SUBMISSION: SSI – 12590060, THE HUNTER POWER PROJECT

I am writing to object to the Hunter Power Project. I share the broad concerns of many others, listed briefly below, but as a local resident will largely focus on more local issues.

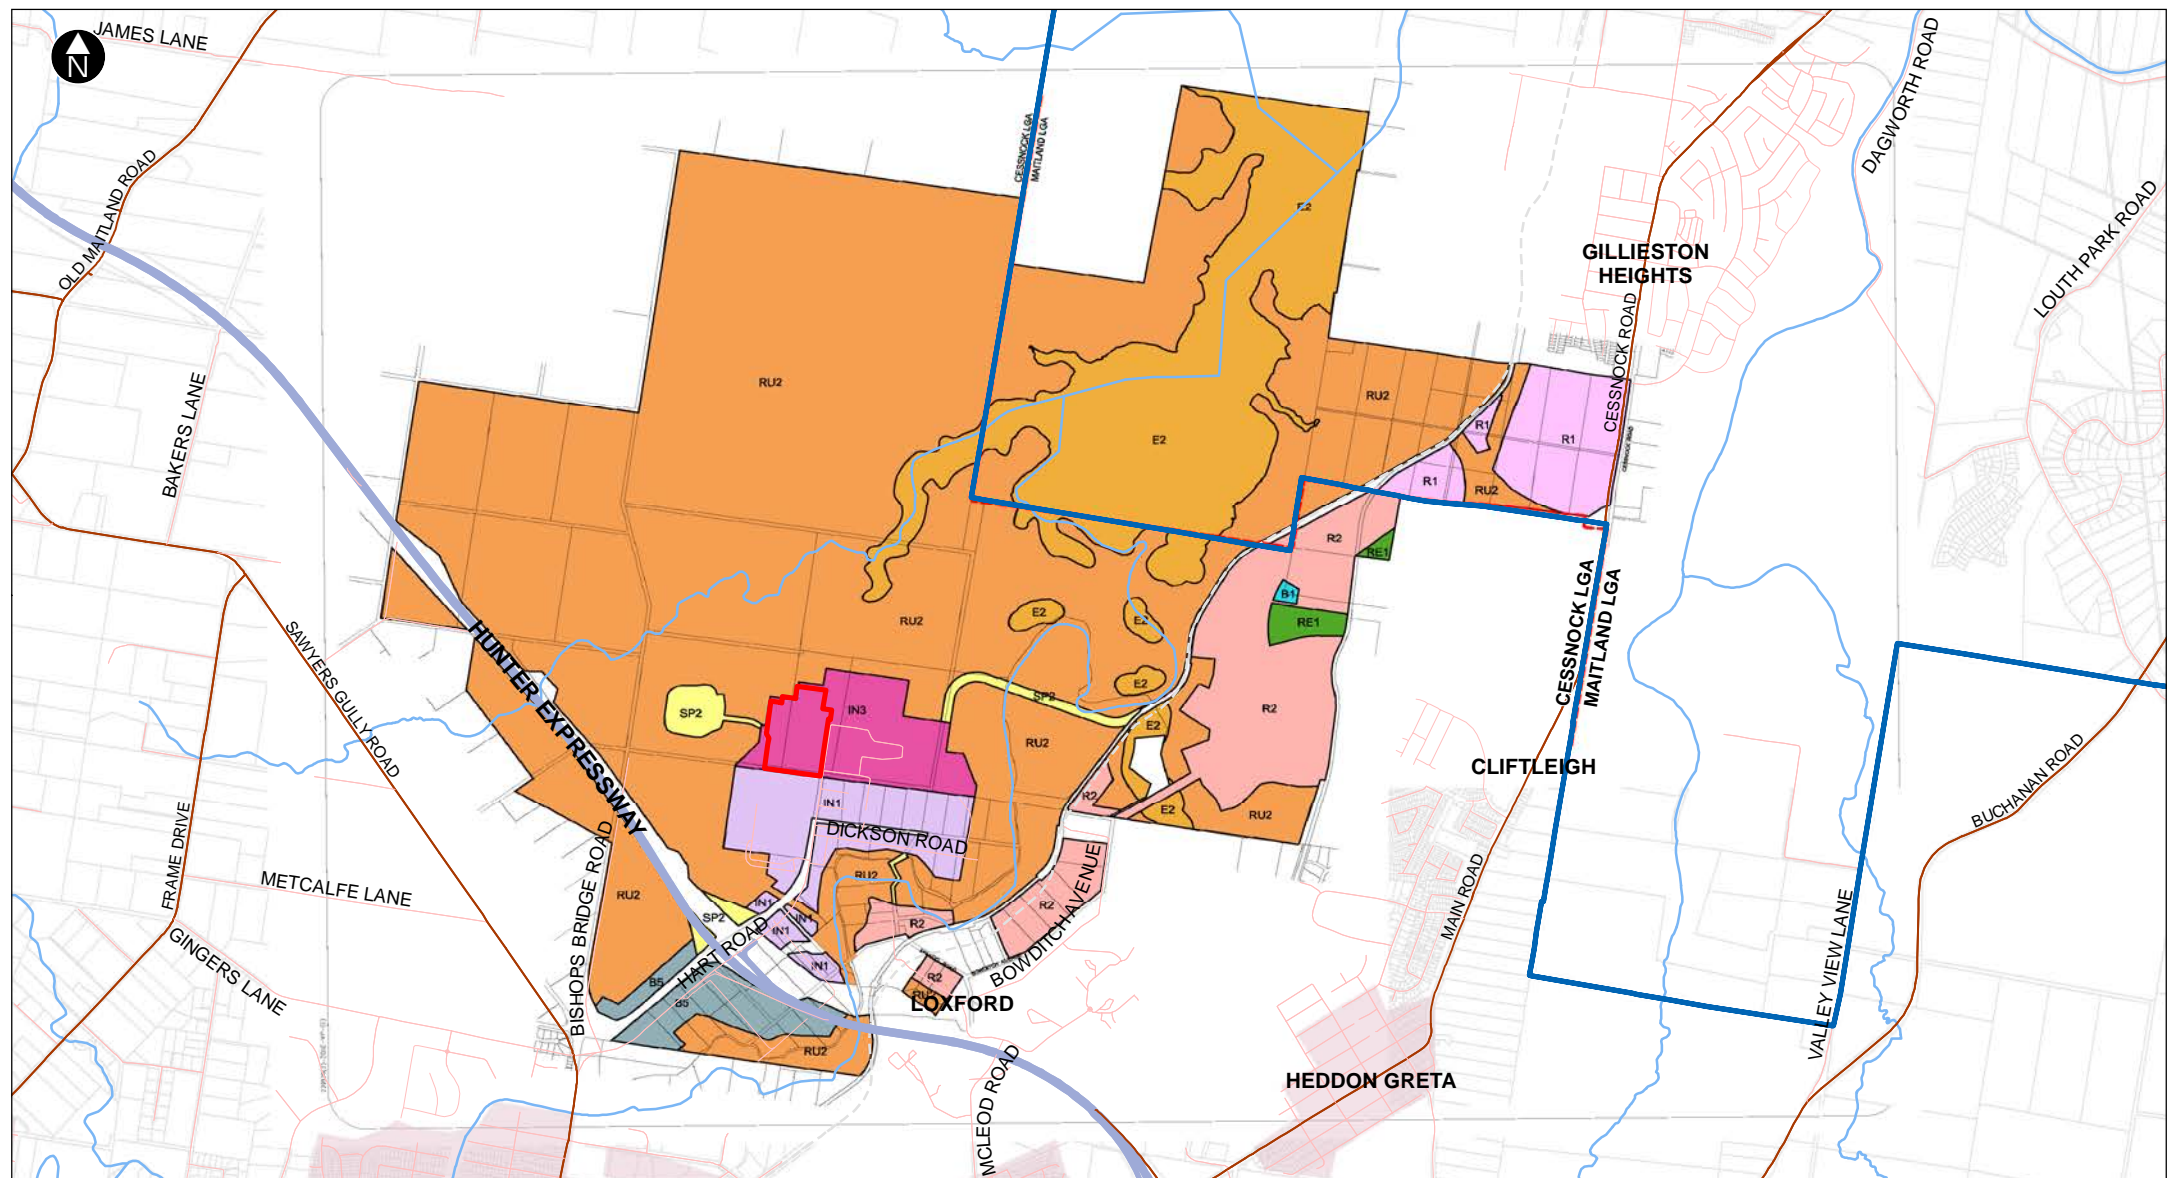
Looking at Fig 2.4 Hydro Kurri Kurri rezoning concept master plan, the proposed residential areas marked R2 appear to be at least as close as the “nearby receivers” at the Colongra site. Why would it be assumed that “nearby receivers” in the Kurri case are going to be any less sensitive to noise than in the Central Coast area? Or is it being assumed that those houses will never be built, due to the proximity of the gas fired power station? The residential areas identified in the Kurri master plan form an important part of the strategy to increase employment in the area and mustn’t be lightly thrown away.
